W SCC CONSULTATION RESPONSE:
County Planning – Minerals & Waste Planning Authority

TO:	Arun District Council Case Officer: Raymond Cole
DATE:	25 June 2020
LOCATION:	Ford Airfield, Ford
SUBJECT:	F/4/20/OUT: Outline planning application (with all matters reserved except for access) for the development of up to 1,500 dwellings (Use Class C3), 60-bed care home (Use Class C2), up to 9,000 sqm of employment floorspace (Use Classes B1), local centre of up to 2,350 sqm including up to 900 sqm retail / commercial (Use Classes A1-A5) and 1,450 sqm community / leisure floorspace (Use Classes D1-D2), land for a two-form entry primary school (Use Class D1), public open space, allotments, new sports pitches and associated facilities, drainage, parking and associated access, infrastructure, landscape, ancillary and site preparation works, including demolition of existing buildings and part removal of existing runway hardstanding.
RECOMMENDATION:	☐ Advice ☒ Objection ☐ Modification ☐ No Objection ☒ More Information ☐ Refusal

Figure 1: Location of WSCC safeguarded sites

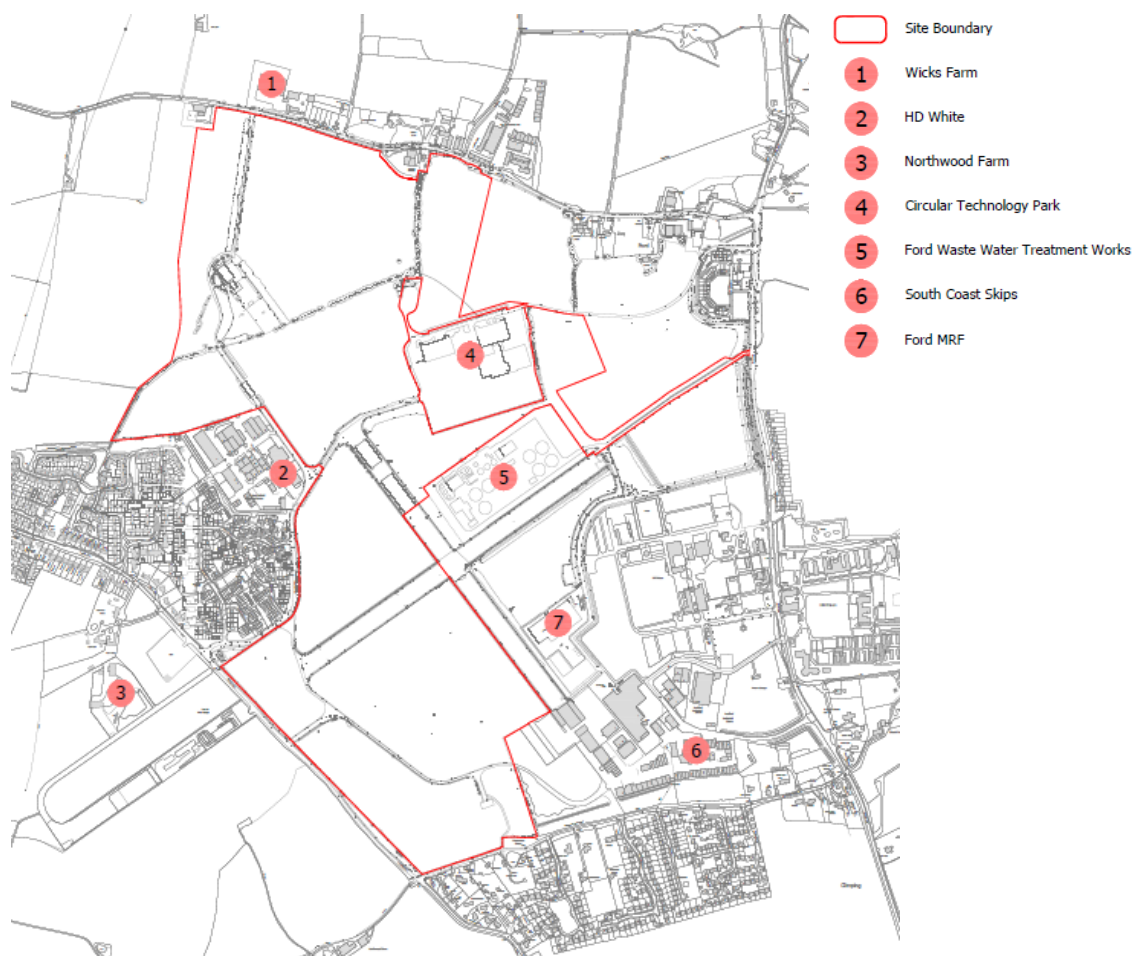
It highlights the close proximity of the application site to these facilities, and limited separation distances from residential properties. However, it fails to identify the proximity of the proposed employment area, which shares a boundary with the New Circular Technology Park (CTP - extant permission W SCC/096/13/F for a major waste treatment facility), and a strategic waste allocation site in the WLP (Policy W10). Potential interactions and impacts upon proposed employment uses should be considered.

The proximity of proposed uses to the CTP including housing, the proposed 'local centre' to the west/north west, and the proposed employment uses immediately adjacent to the east remain of key concern. Given that this site is allocated as a strategic waste site, and planning permission has been granted (and part implemented) for an energy recovery facility, future operations are likely to have a greater impact than is currently the case.

Figure 2: Indicative extent of acoustic barrier at Ford Industrial Estate

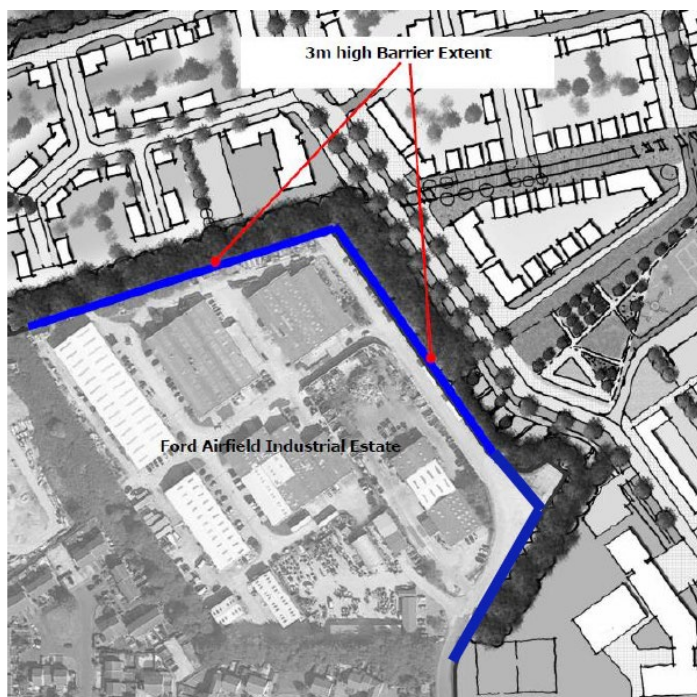
Some screening surrounding existing waste management facilities is identified; however, it is limited in scope. Further, the Statement offers little consideration of the how such screening would address or mitigate any impacts arising from proximity to the proposed development.

Information on proposed mitigation measures remains generic and limited. Although noise and odour mitigation recommendations are muted (e.g. through potential provision of buffer zones, acoustic barriers/bunds, and gardens and residential properties oriented in such a way that habitable rooms dwellings do not face industrial buildings), there is little detail on these measures, and they are only described in respect of some number of the neighbouring waste facilities.
